Re: Baze-Inoguchi Residence  
Building Permit #2006-188

The following is in response to the Intake Comments CST dated July 21, 2020 for your review.

Re: Baze-Inoguchi

I have reviewed the building department intake comments and made the following revisions in response to these comments.

3  
A9  
REAR ELEVATION (WEST)  
SCALE: 1/4" = 1' - 0"

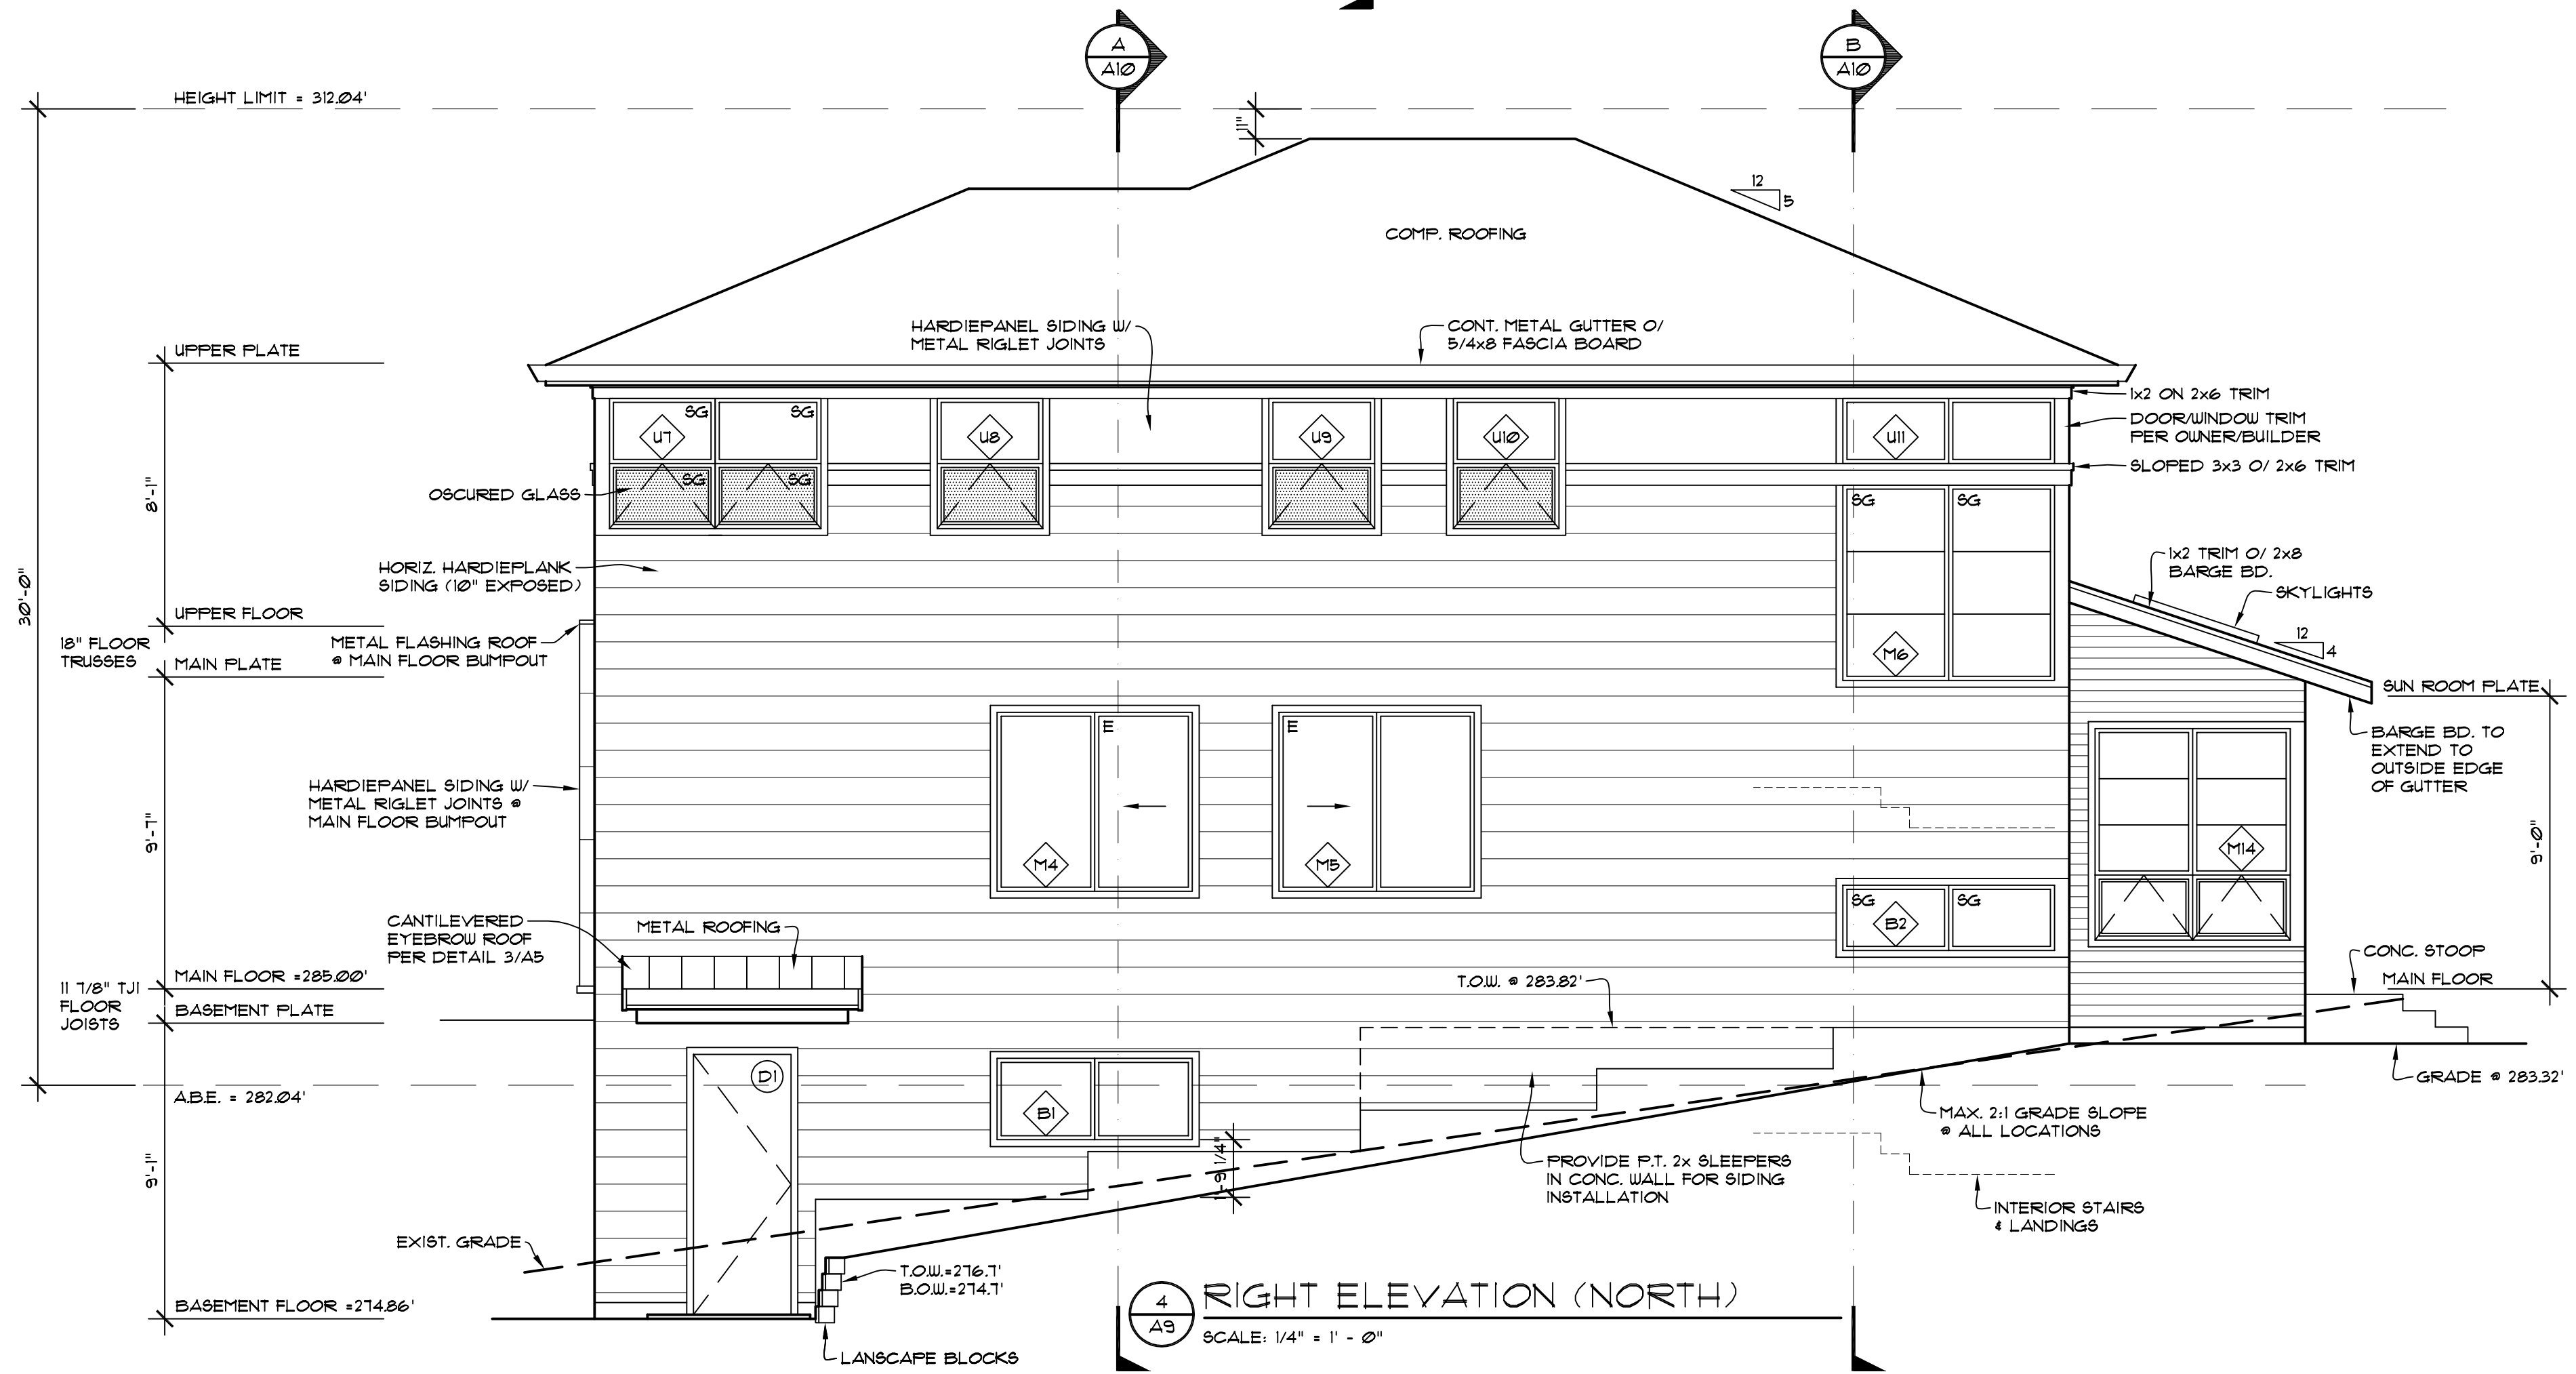
1. Added building height note.
2. Added existing grade lines.
3. Added downhill building façade height dimension.
4. Added grading cut & amount outside footprint to site plan.

MAIN FLOOR SHEAR WALLS  
1/8"=1'-0"

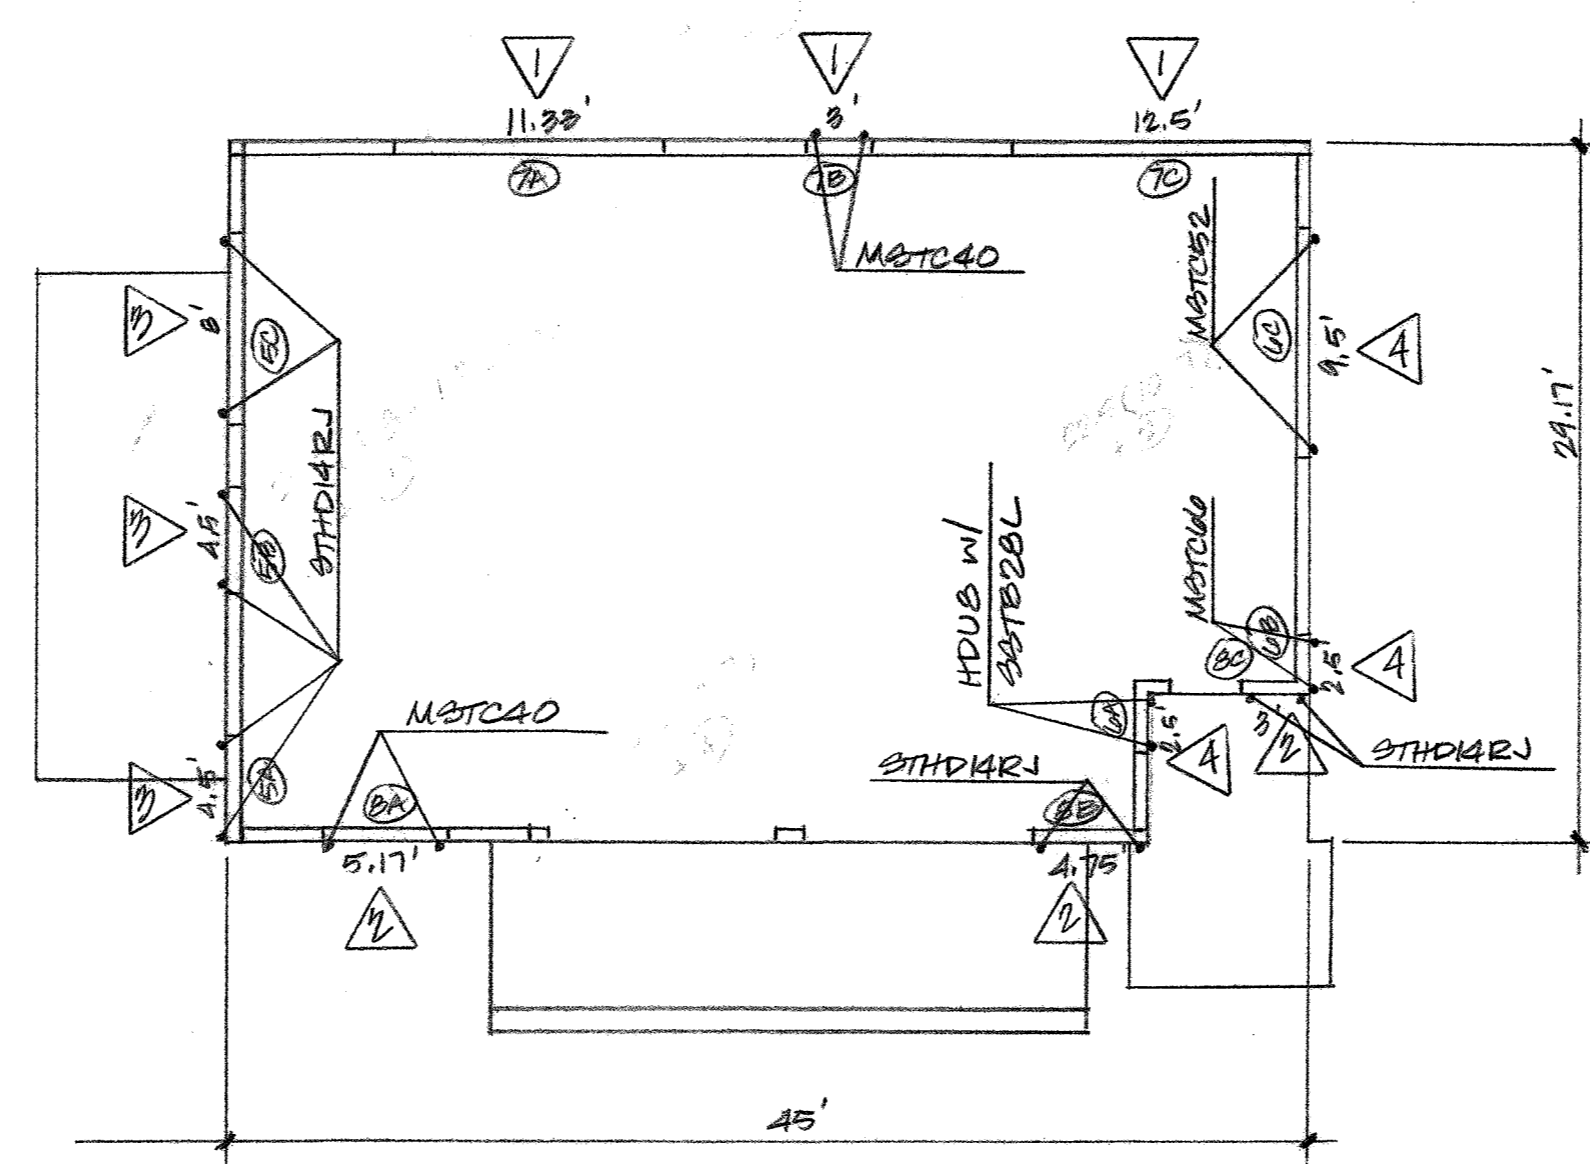
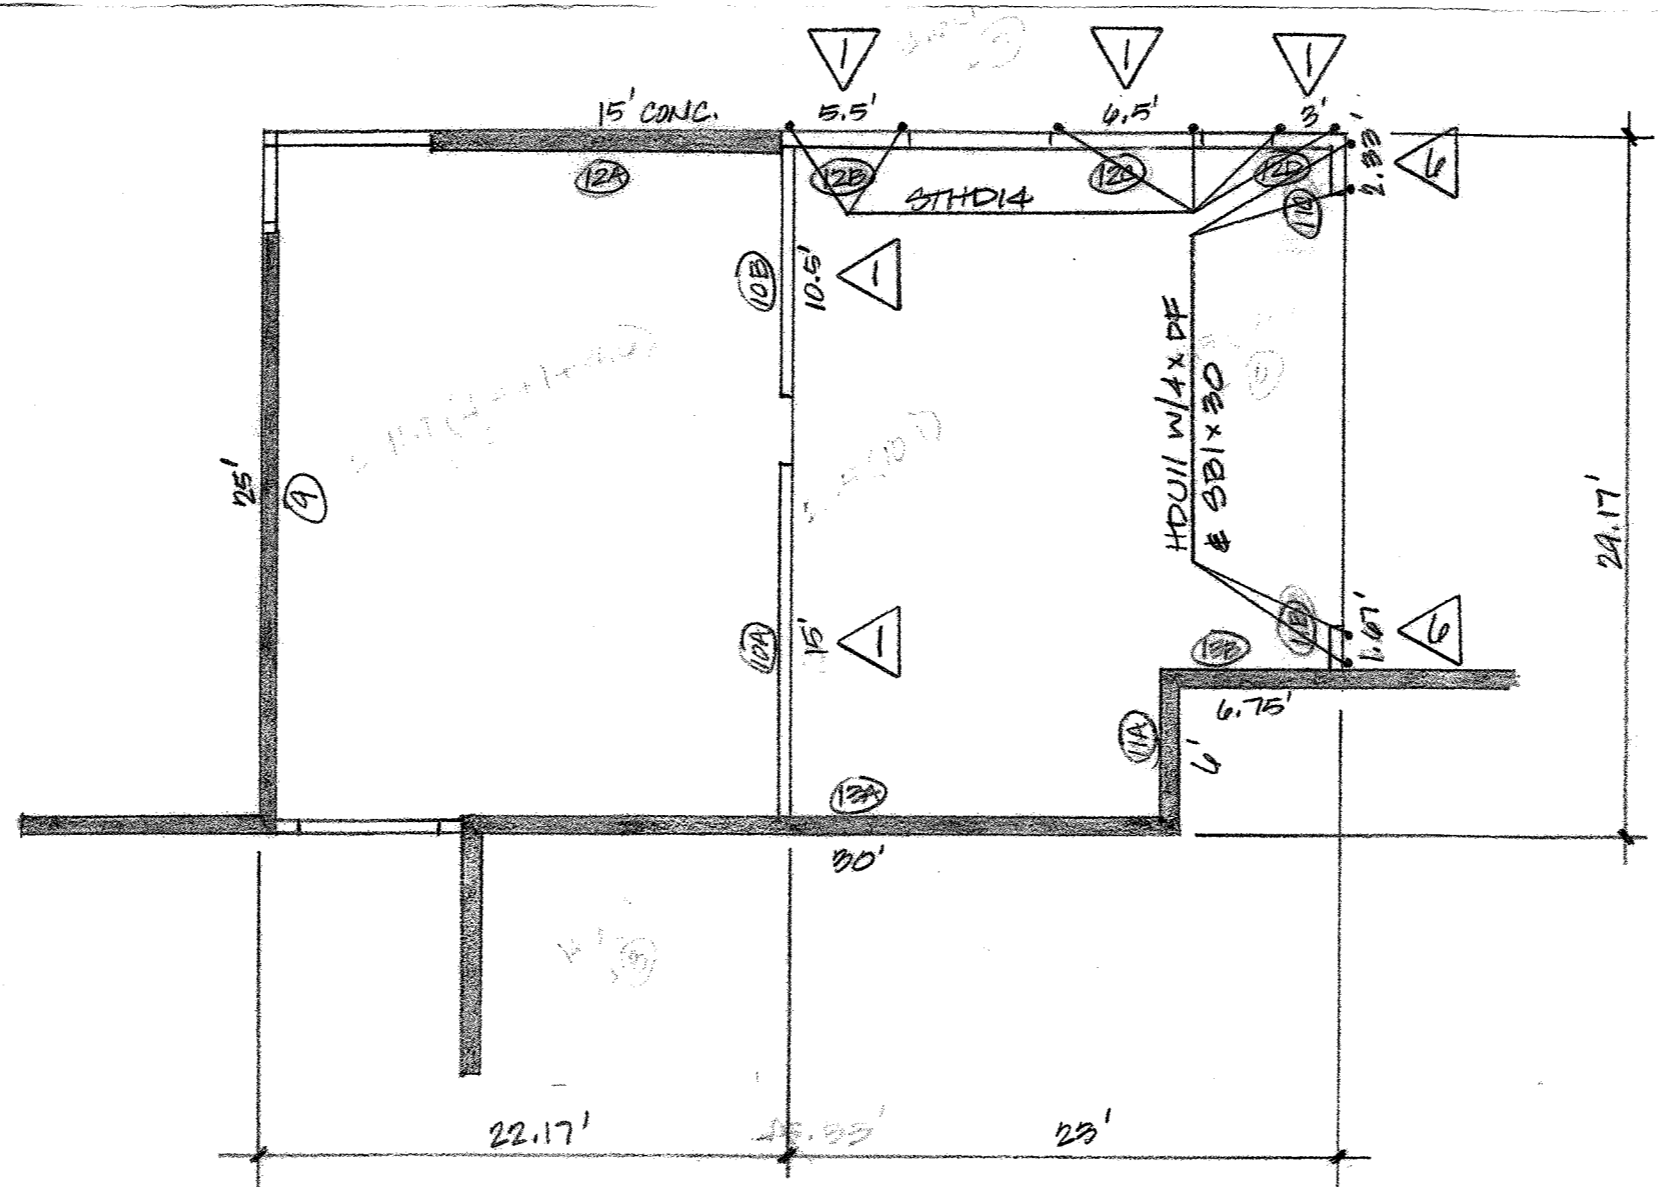
1. The lateral analysis has been revised using  $K_{zt} = 1.9$ . The revised calculations and the sheet S1 with the revised shear wall plans are attached.
2. The retaining wall calculations and a updated sheet S3 are attached.
